PL- Consultation- Conservation Officer response

R/1/26/L

Land to the north of Rustington Convalescent Home Sea Road Rustington BN16 2LZ

Listed building consent for the demolition and reconstruction of the western elevation of the laundry building.

title
Laundry Building
Proposed Plans and Elevations

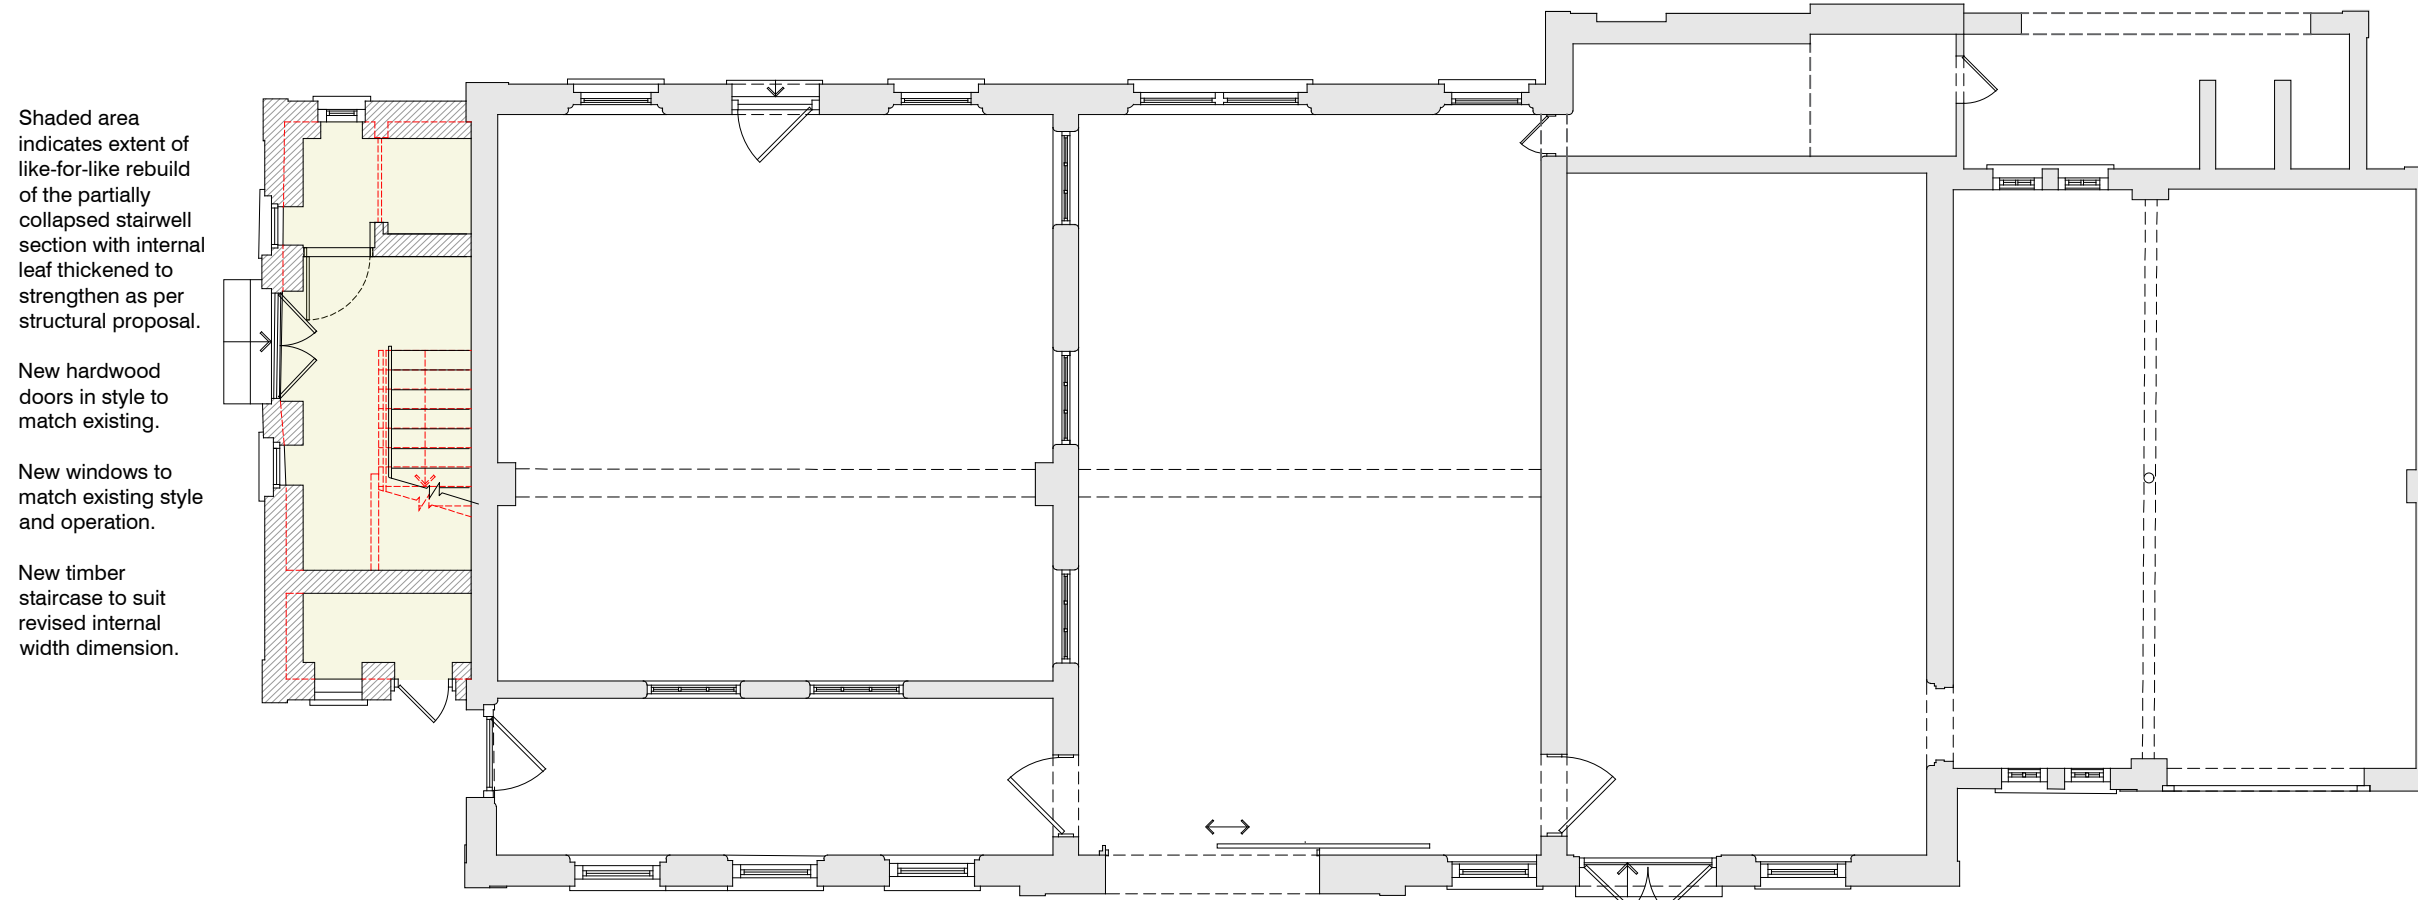
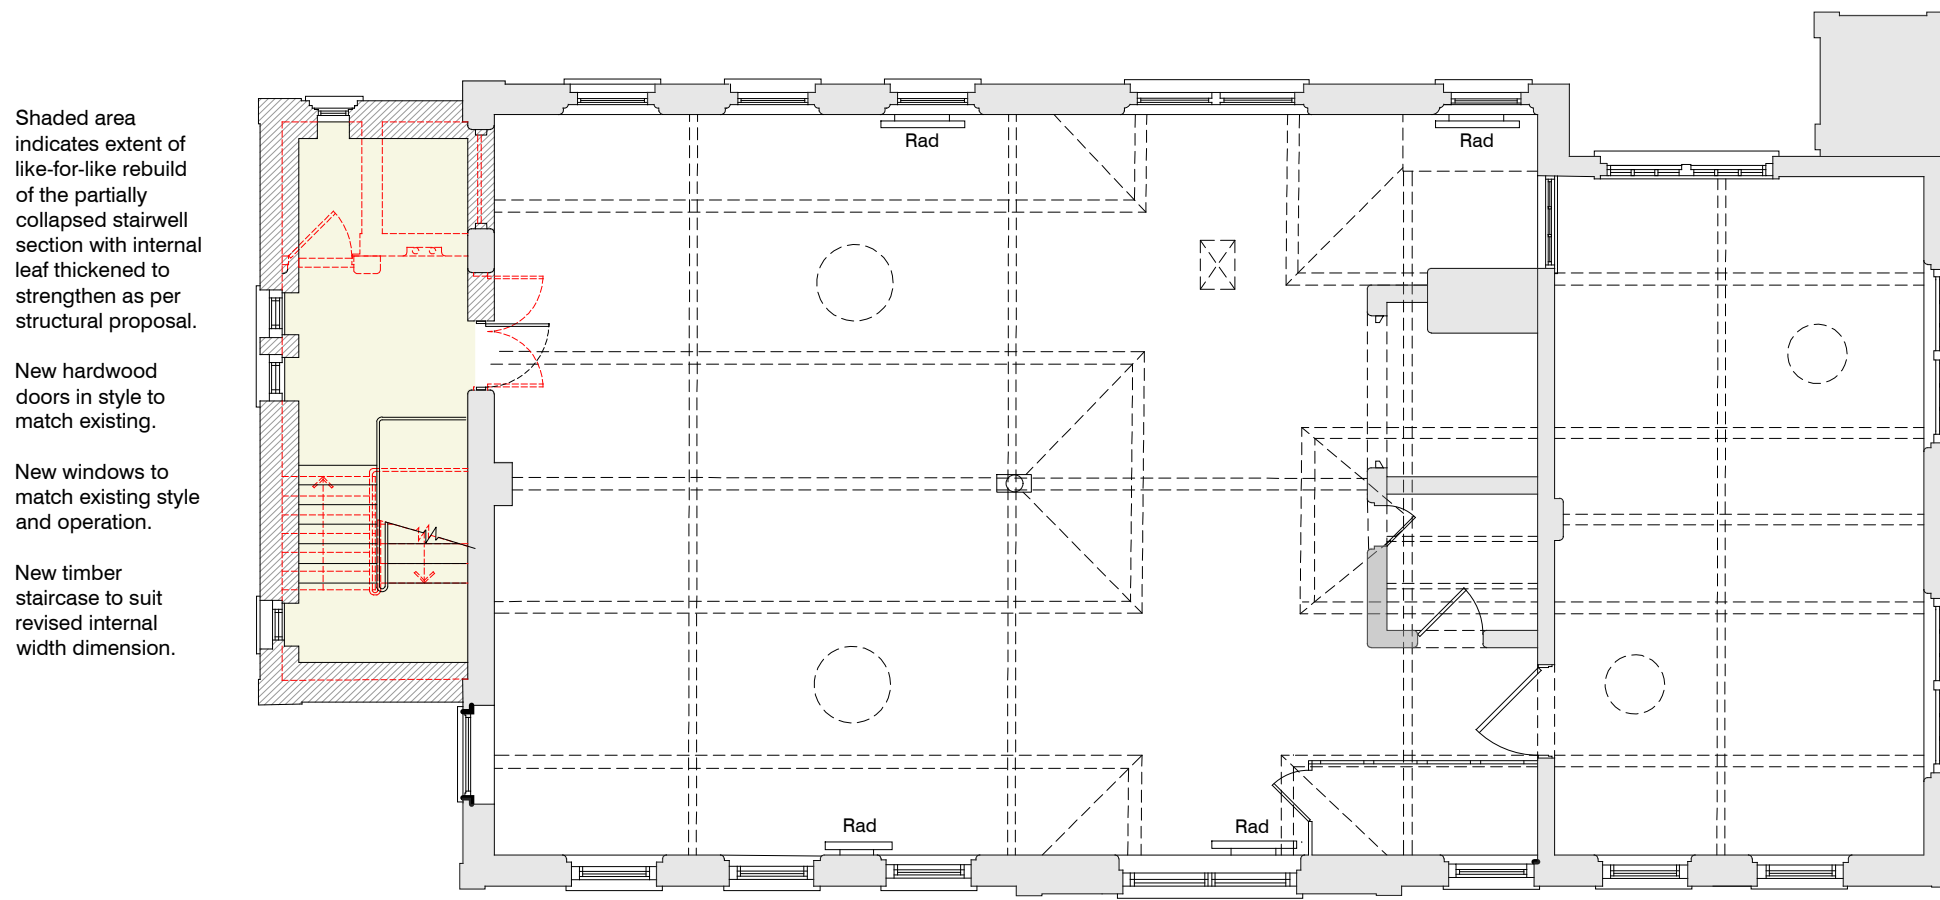
The proposal is for the demolition and reconstruction of the western elevation of the laundry building. Whilst the proposal is significant it is required as a result of an ongoing lack of maintenance on the building and current and recent poor weather. I should point out that whilst it is disappointing that such a large area will need to be re-built, it is appositive that the applicant intends to replicate the existing building and detailing as part of the rebuilding works, whilst also re-using many existing materials where possible. I have been on site and met with the applicant's heritage and structural advisors and based on the circumstances am happy with the scheme as proposed.

I note that reference is made to a recent discharge of condition application when discussing potential replacement windows. However, as far as I am able to determine, the windows associated with that submission, appear to be of modern materials and construction and are therefore not appropriate for this building. Any new windows or doors should be of a design and material that is appropriate to its historic character. Further details should be secured by means of a suitably worded condition.

I should also point out that this application relates only to the western element of the building. Any works to the remainder of the building, such as the replacement of wall ties in other sections, would require separate consent.
